ST MARYS FREIGHT HUB

RESPONSE TO SUBMISSIONS

PREPARED FOR:
PACIFIC NATIONAL

OCTOBER 2019

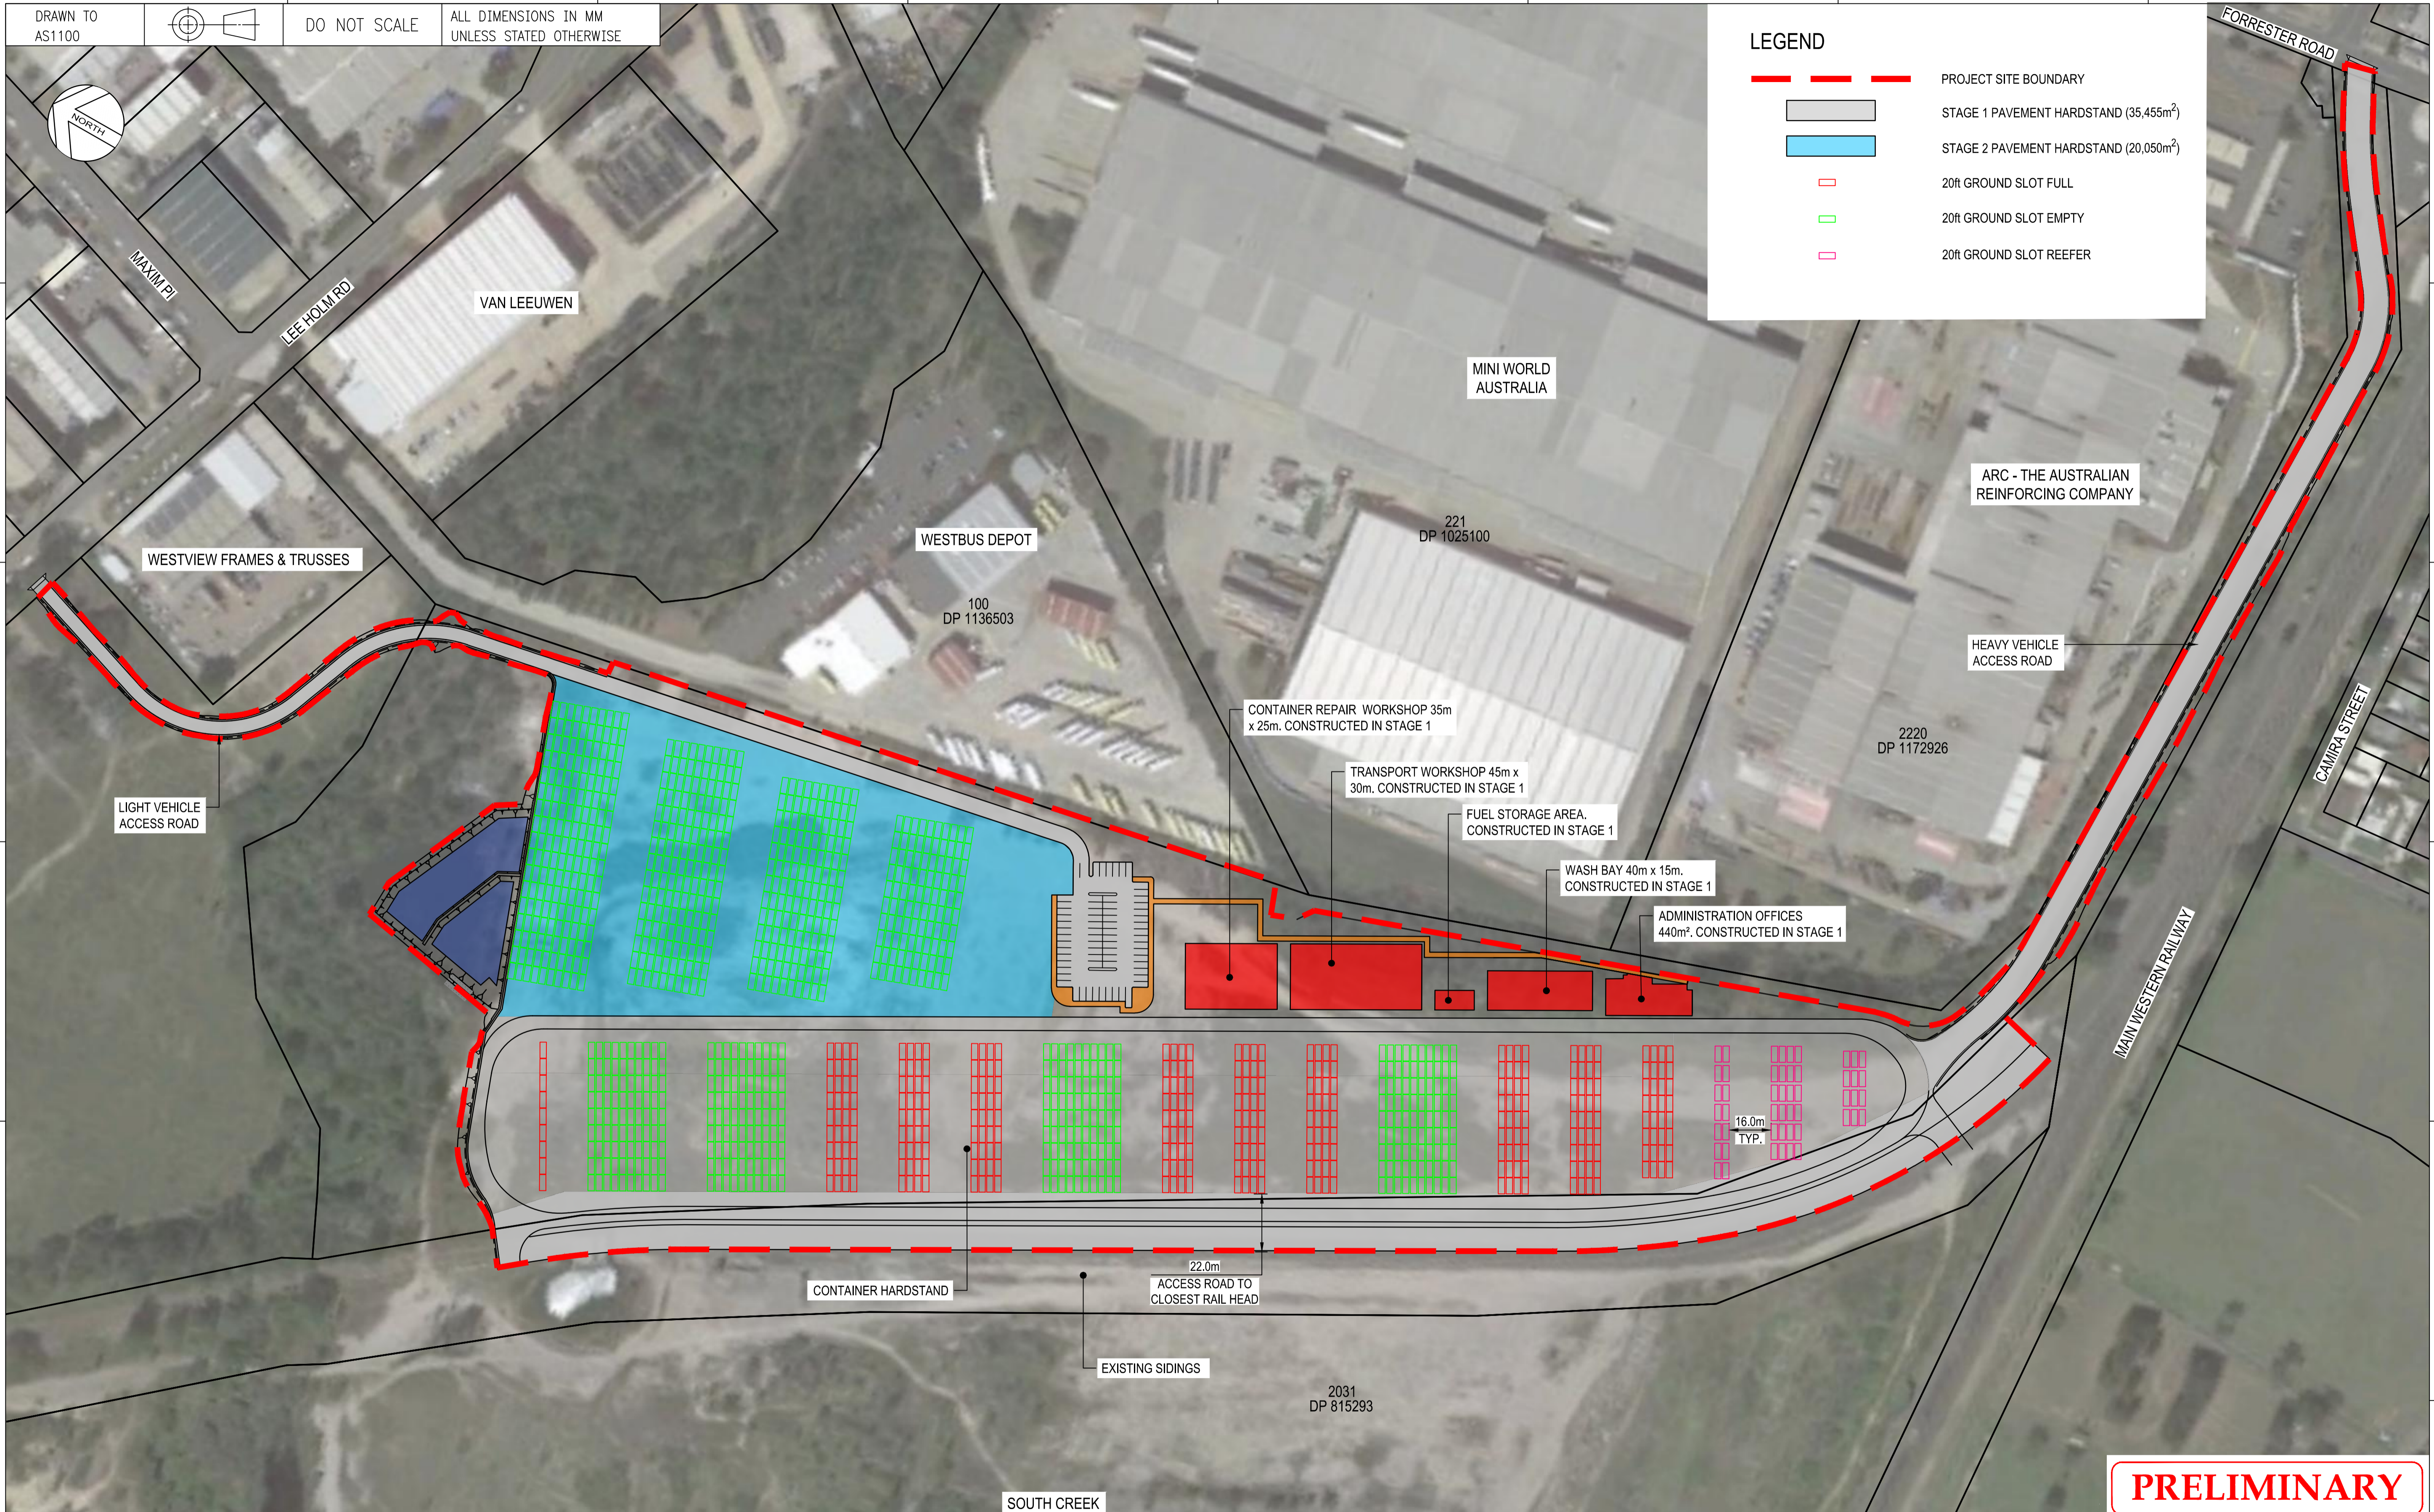
The concept layout of the Freight Hub has been modified to reflect the change in access arrangements ensuring appropriate separation of truck and light vehicle movements within the site. The use of Lee Holm Road and Christie Street for heavy vehicle traffic was a key concern in various submissions, including Penrith City Council. Heavy vehicle access is now from Forrester Road under Option 4. There will be no heavy vehicles accessing Lee Holm Road or Christie Street.

- The internal layout has been modified to reflect the changes in the access arrangements ensuring appropriate separation of truck and light vehicle movements within the site; and

- Staff and visitor parking have been relocated to provide direct access from Lee Holm Road and suitable pedestrian access to work and visitor areas separate from internal truck movements.

Key changes to the design and operations are summarised as:

- Revised site layout and development footprint, including:
 - The development area of 9.6ha is essentially the same land area with modification of development footprint as a result of:

- changing the access from Lee Holm Road from heavy vehicles to light vehicles; and
 - inclusion of additional land for a bio retention filtration basin at the northern end of the development site, abutting Little Creek;

- Light vehicle access from Lee Holm Drive (previously from Forrester Road);
 - Heavy vehicle access from Forrester Road (previously from Lee Holm Road);

- Revised route for heavy vehicle movements (Option 4);
 - Provision for two (2) B Double vehicles to wait on site prior to exiting to Forrester Road, to allow oncoming traffic to enter the site;

- Controlled heavy vehicle access at Forrester Road entrance;
 - Staff and visitor car parking relocated to co-locate with operational and administrative buildings;

- Relocation of the fuel storage facility to abut operational buildings;
 - Relocation of the administrative office building, away from operational buildings and activity; and

- Construction of an acoustic fence along the southern boundary of the access leg to Forrester Road.
